AMENDMENT RECORD SHEET - POST DECISION

Application no: H06/0428/99

Description: Erect new dwelling with
detached garage

Location: Rectory Lane
Gedney Church End
Spalding
Lincs

project no.	drawing no.
1469	AB/9

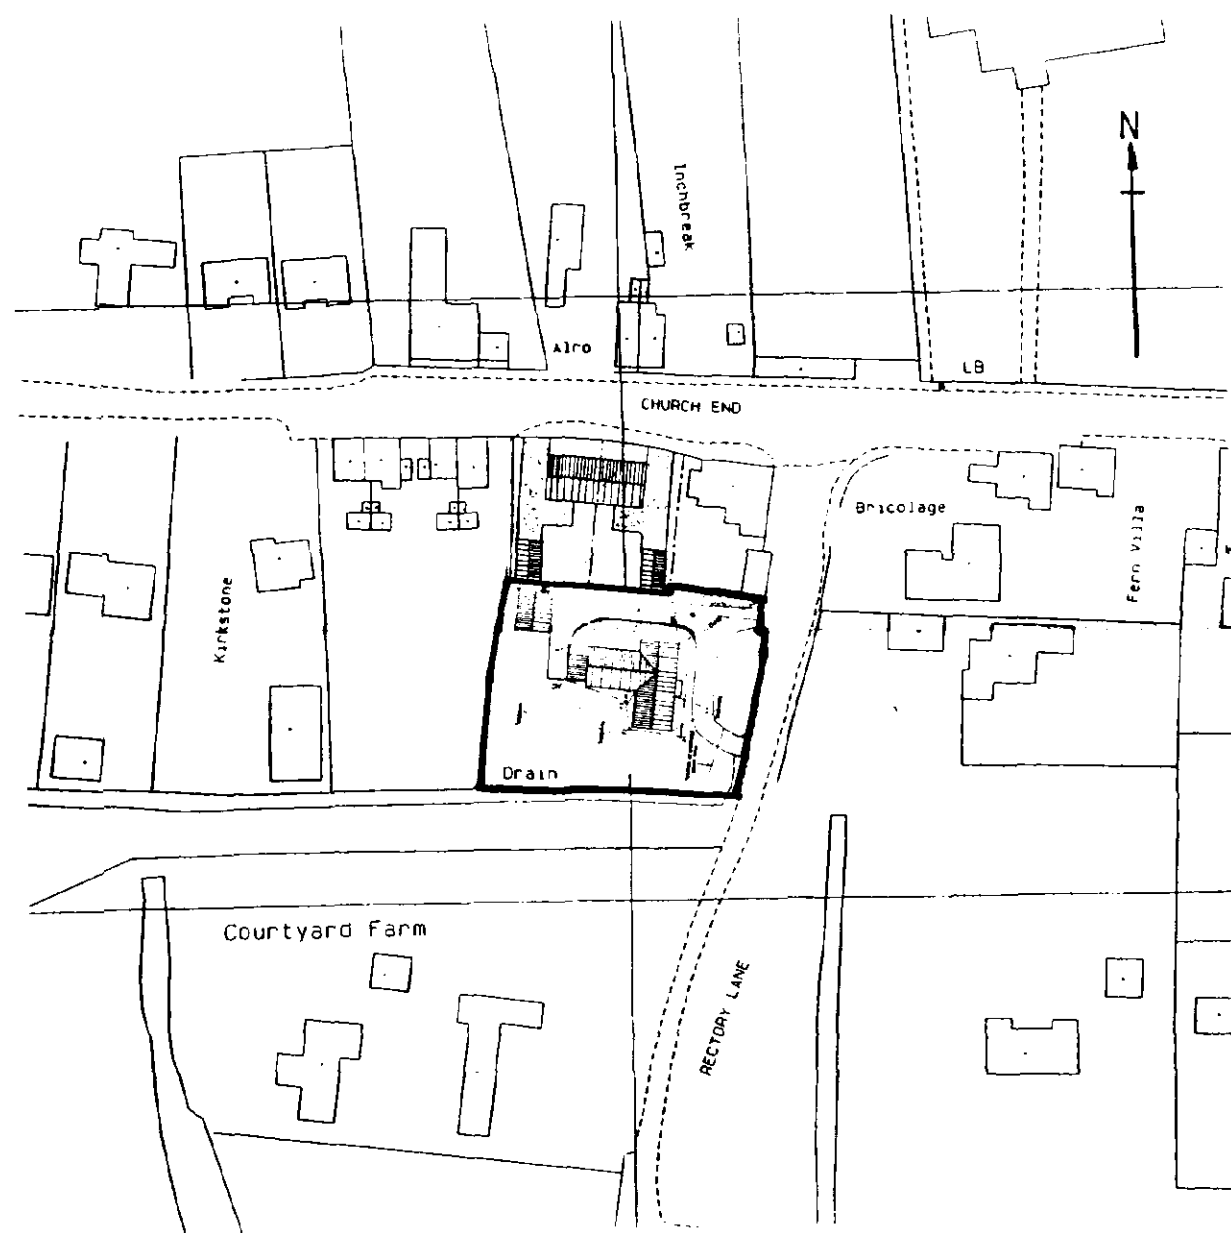
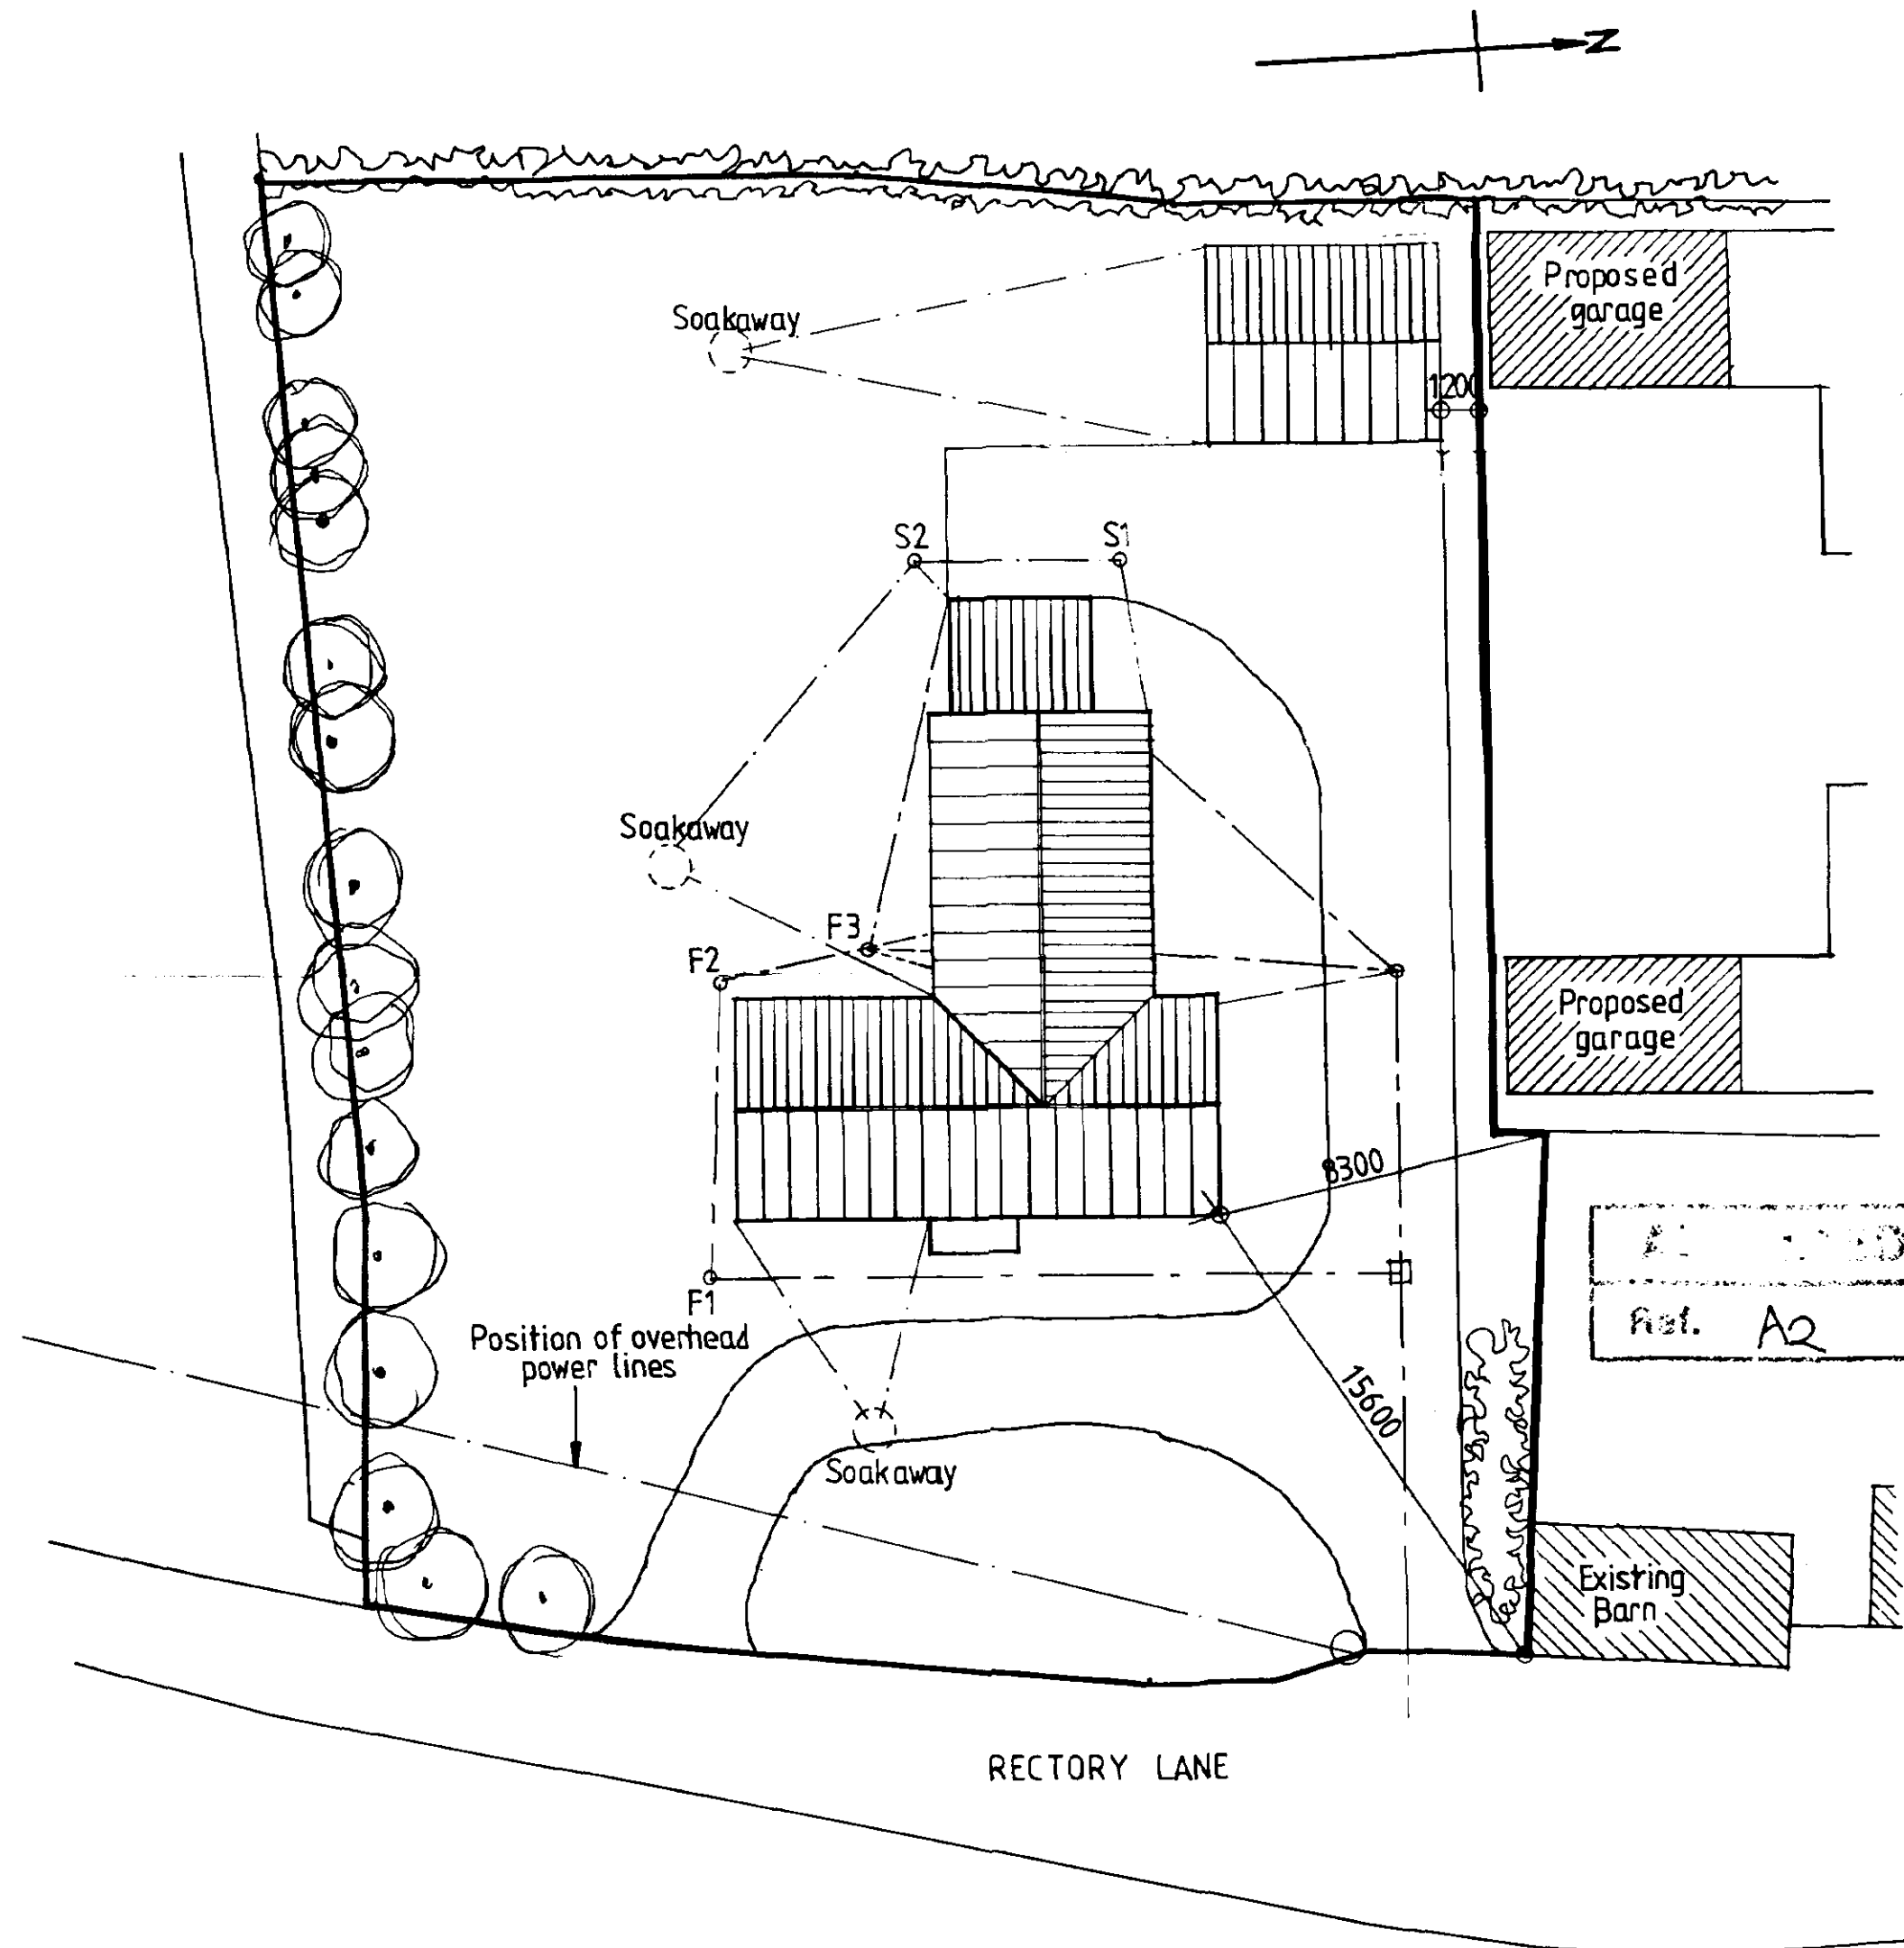
WINDOW AND DOOR SIZES REVISED
UTILITY EXTENDED
WINDOW ADDED IN UTILITY ON SOUTH ELEVATION
WIDTH OF REAR WING EXTENDED
STONE SUB SILLS ADDED
MINOR ADJUSTMENT TO SETTING OUT POSITION

Amendment: Minor alterations to exterior and siting
Dwg. No. AB/1, AB/9 and AK/2 Rev 3
